Add text:
PCD Filing No.: SF-21-022

TRAILS AT ASPEN RIDGE				
ROADWAY & STORM IMPROVEMENT PLANS ROADWAY & STORM PLANS				
ROAD CENTERLINE KEY MAP				
DESIGNED BY:	TRC	SCALE	DATE ISSUED:	APRIL 2021
DRAWN BY:	LCB	HORIZ. 1" = 80'	SHEET	4 OF 50
CHECKED BY:	NMS	VERT. N/A		
				DRAWING No. RD00

DESIGNED BY:	TRC	SCALE	DATE ISSUED:	APRIL 2021	DRAWING No.
CHECKED BY:	NMS	HORIZ	N/A	SHEET	3 OF 39
		VERT.	N/A		GN02

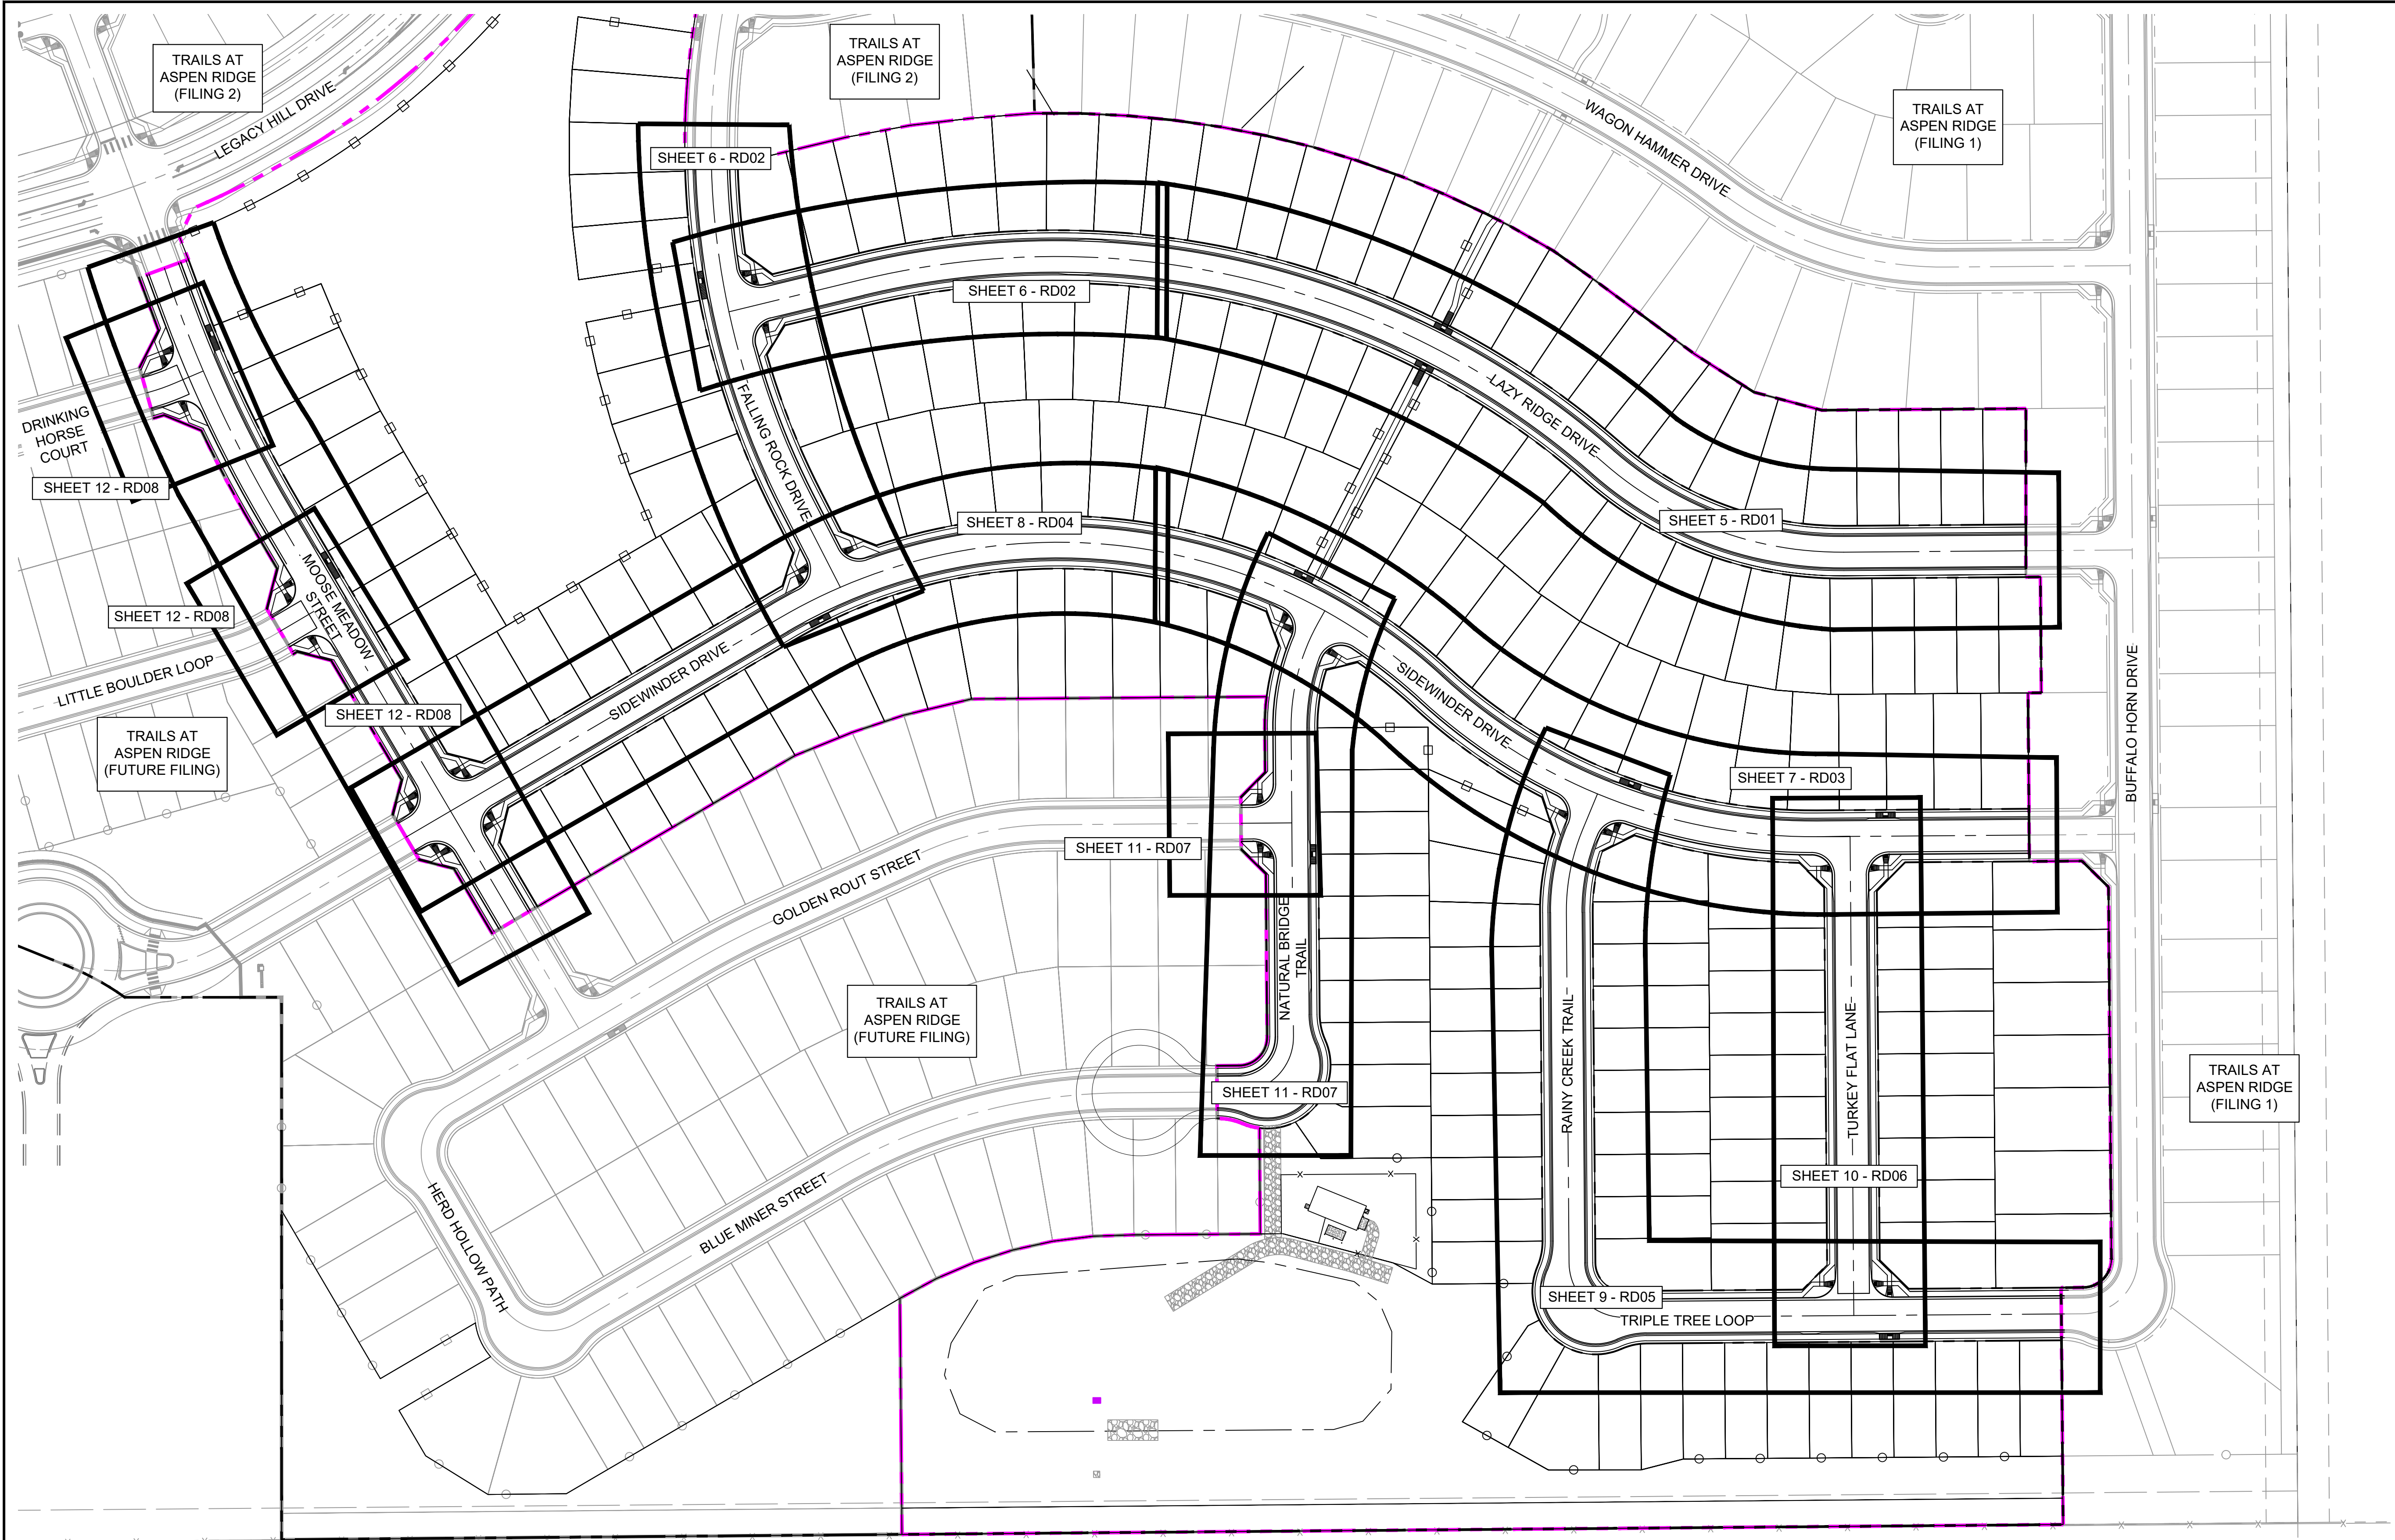
Include the water and sanitary sewer plans or upload as a separate utility construction documents for review and approval.

Add the notes from detail SD_2-26
